DRB CASE ACTION LOG

DRB Application No.: 04DRB-00023 (P&F)

Project # 1003182

Project Name: LANDS OF THE BN&SF RAILWAY

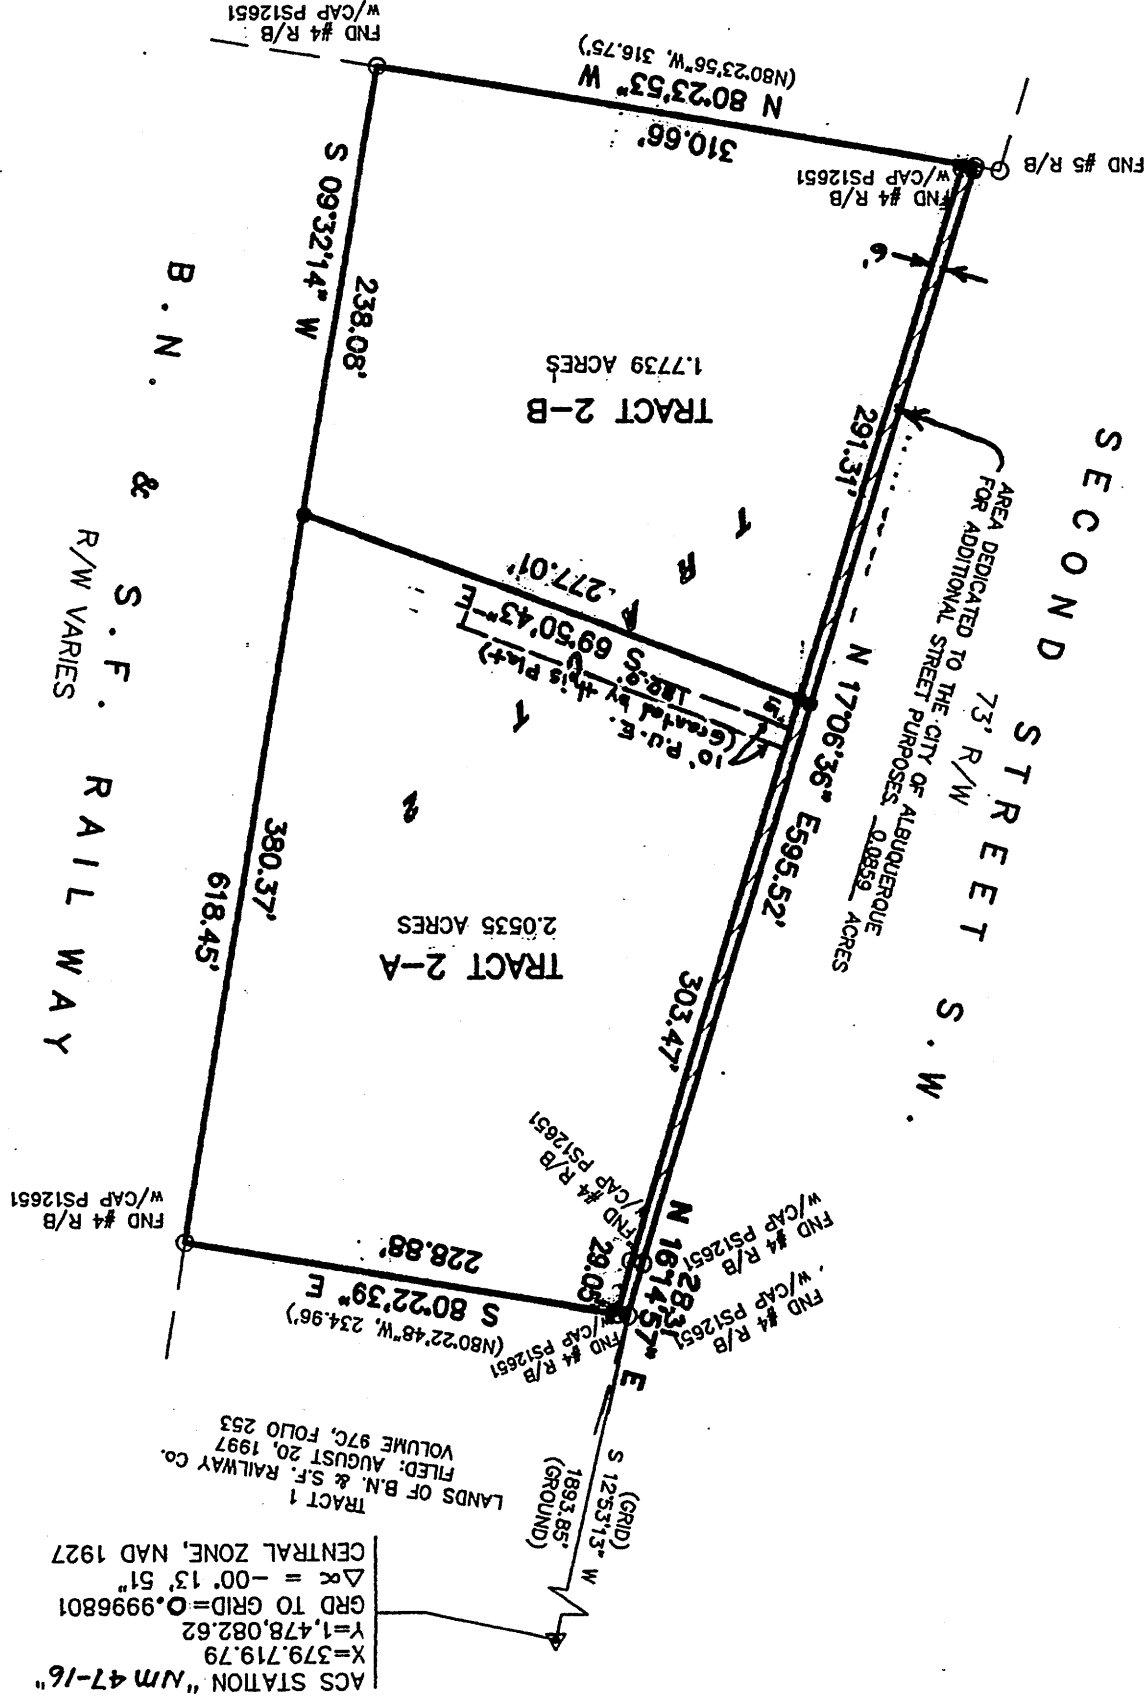
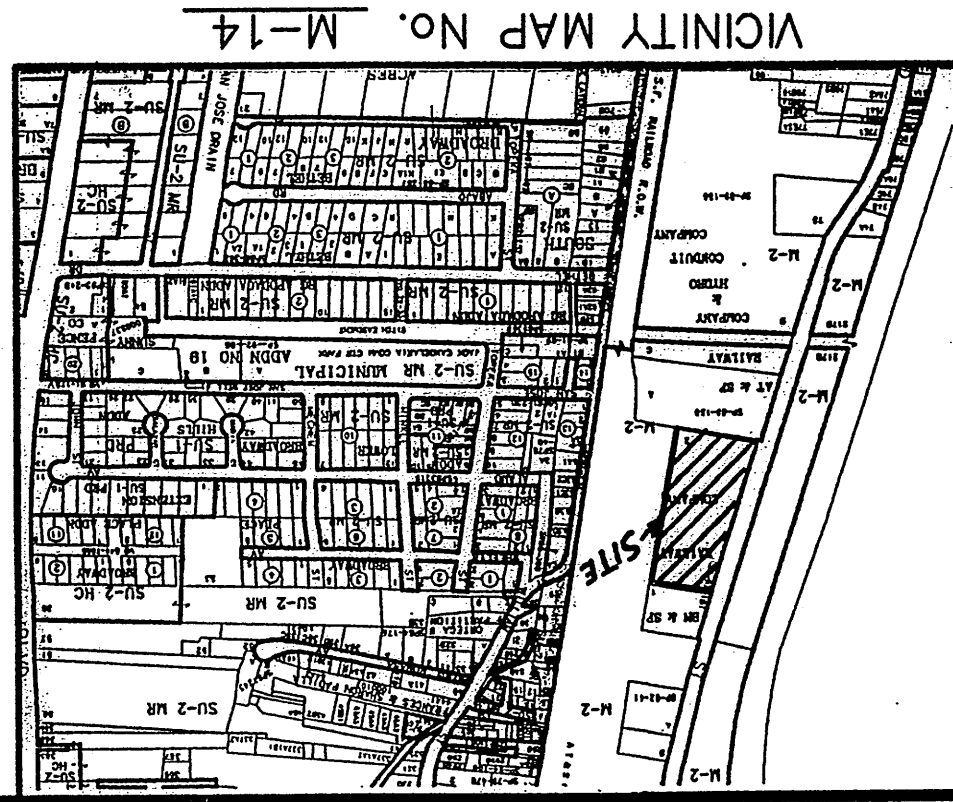
TRANSPORTATION: Need 10' R-O-W Dedication for BIKE LANES

TRANSPORTATION: Need 6' R-O-W DEDICATION for BIKE LANE

_____ **OK 9/15 9-27-04**
